# WHIPPLE-CALLENDER ARCHITECTS

March 4, 2014

**RE: 200 Riverside Industrial Parkway, Portland Me.**

## AMENDMENT #1 – ADDITION S.F. INCREASED TO 3,750 S.F.

**PROPOSED ADDITION TO FORM SYSTEMS
SITE PLAN W/ TITCOMB ASSOCIATES
SURVEY AS BASE**

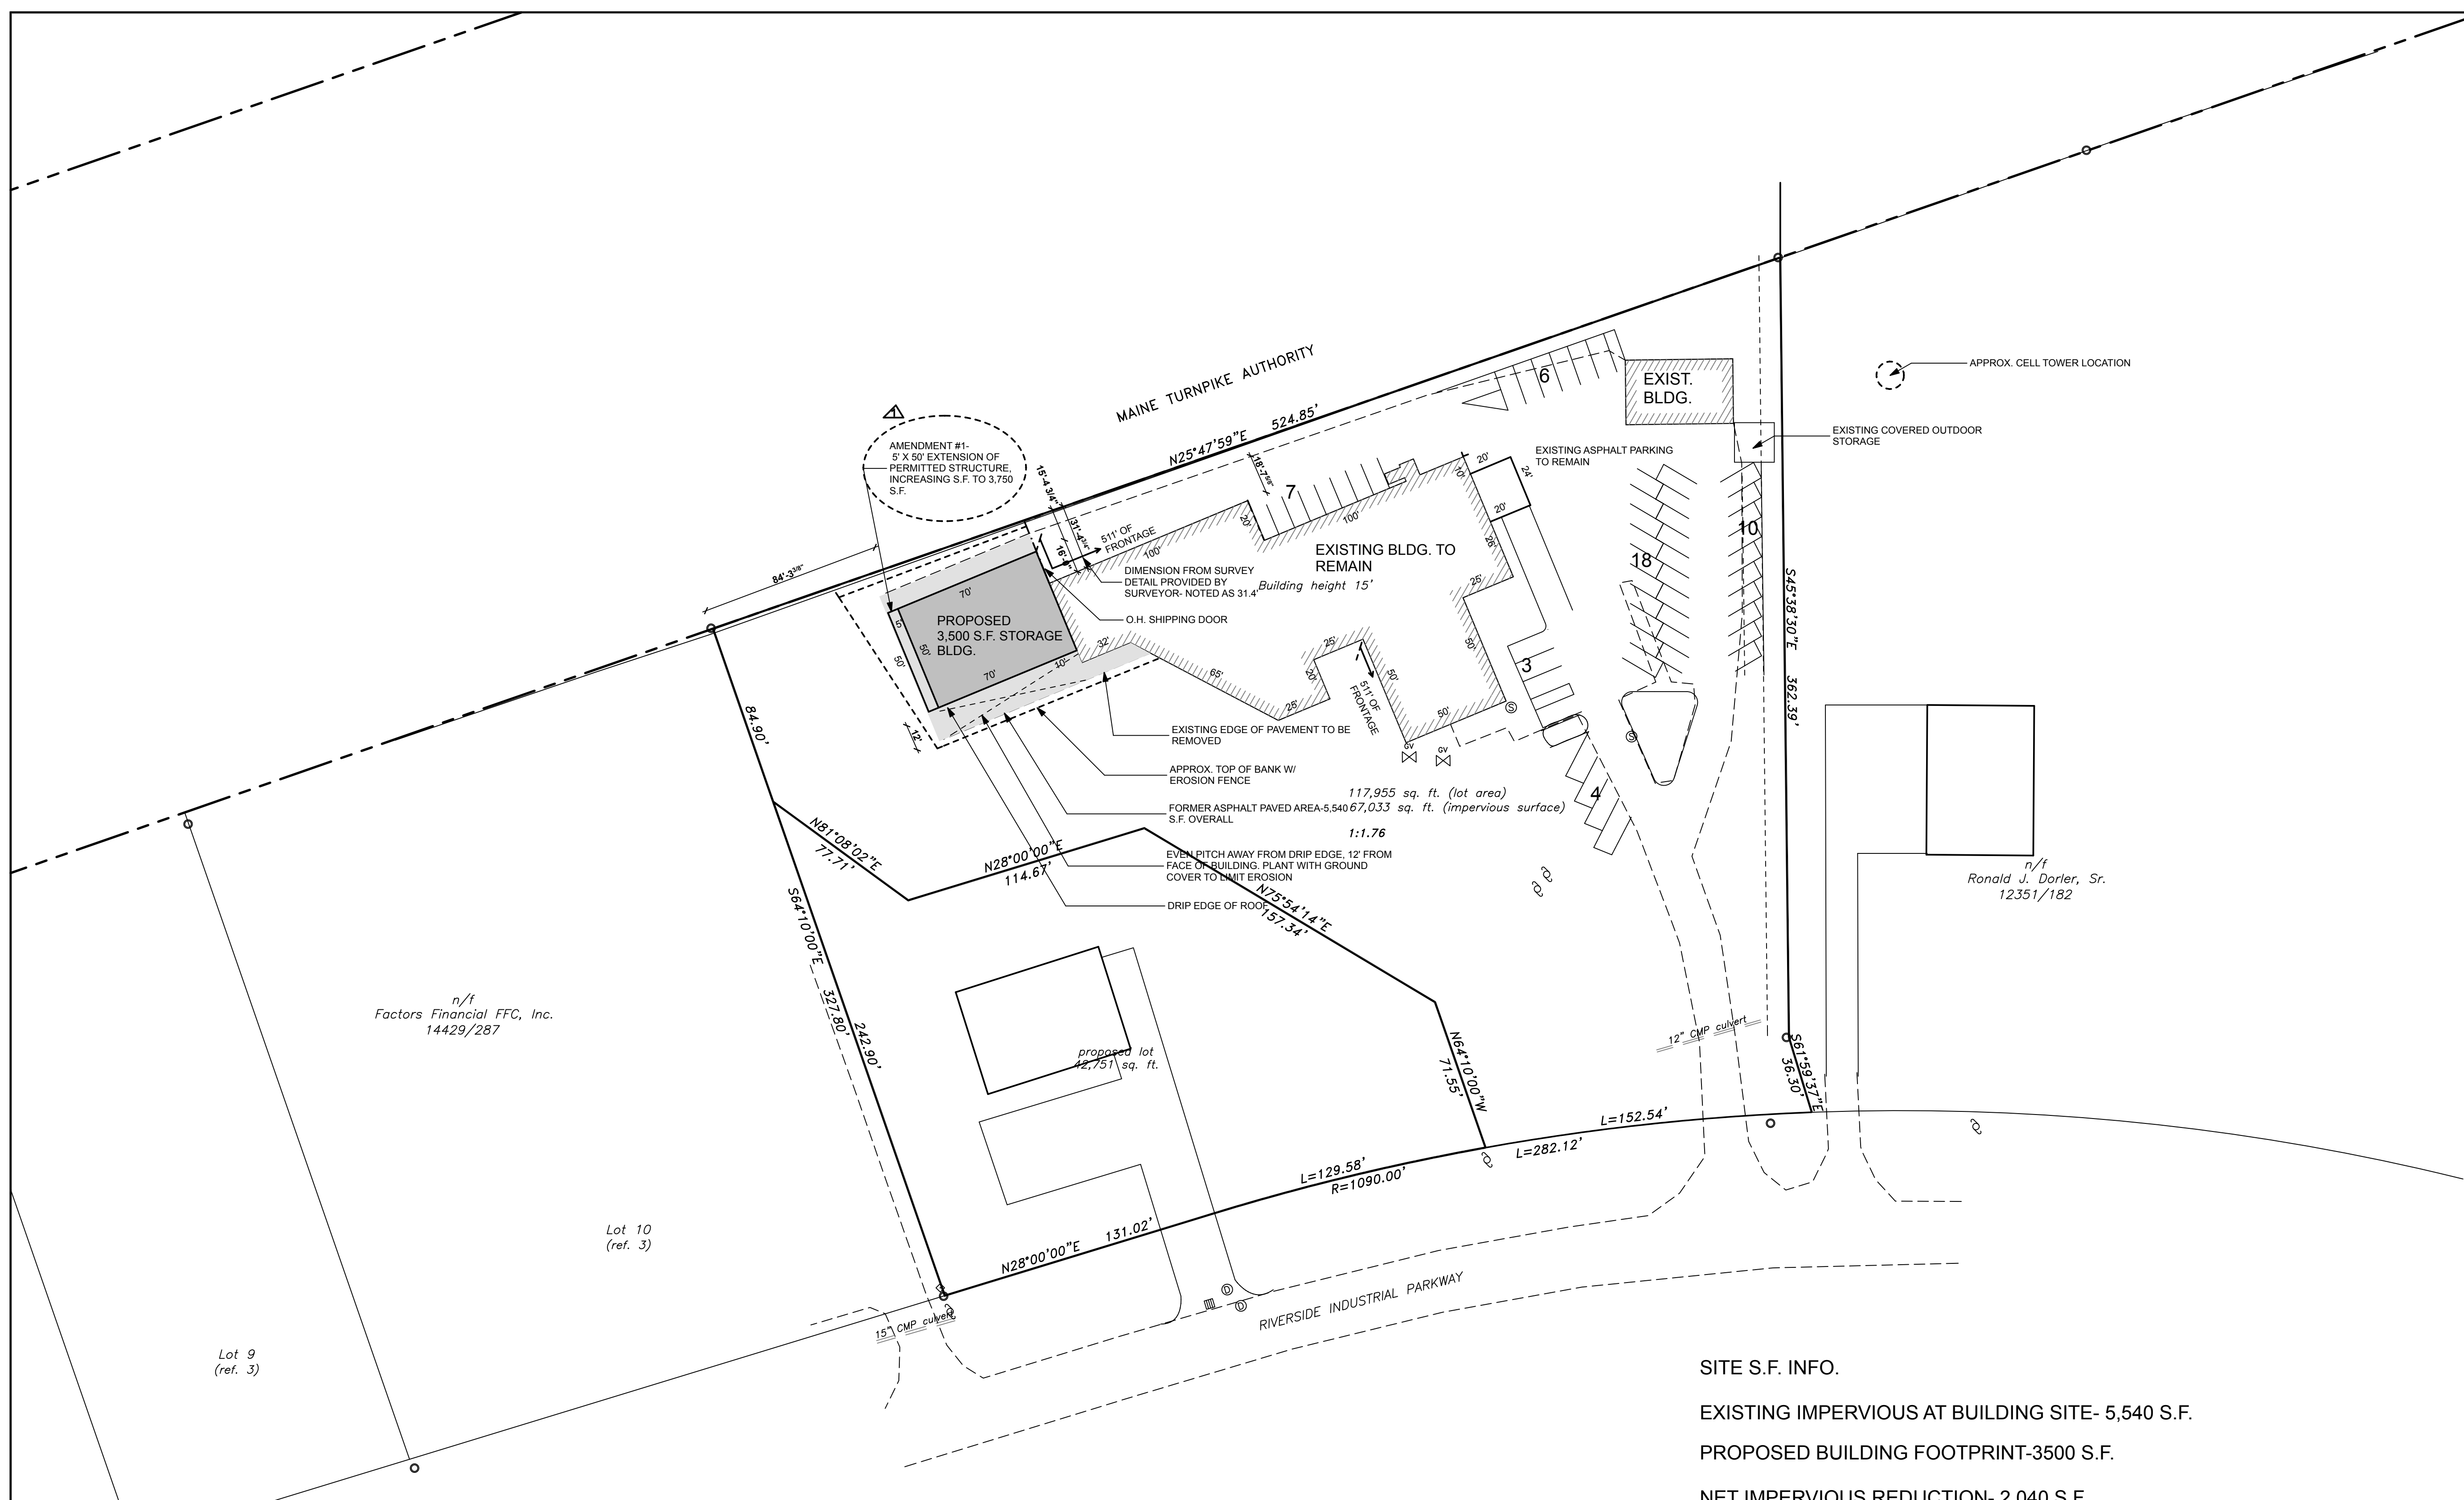
**Max. permitted imperv. Surface ratio- 75%. Based upon the survey, we are at 67,033 s.f of impervious with a 117,955 s.f. site or 56.82 % impervious. Impervious area will be decreased by 2,040 s.f. as a result of this work.**

**AMENDMENT #1 ADDS 250 S.F. TO IMPERVIOUS CALCS –REVISE IMPERVIUOS AREA TO 57.04% < 75 % OK**
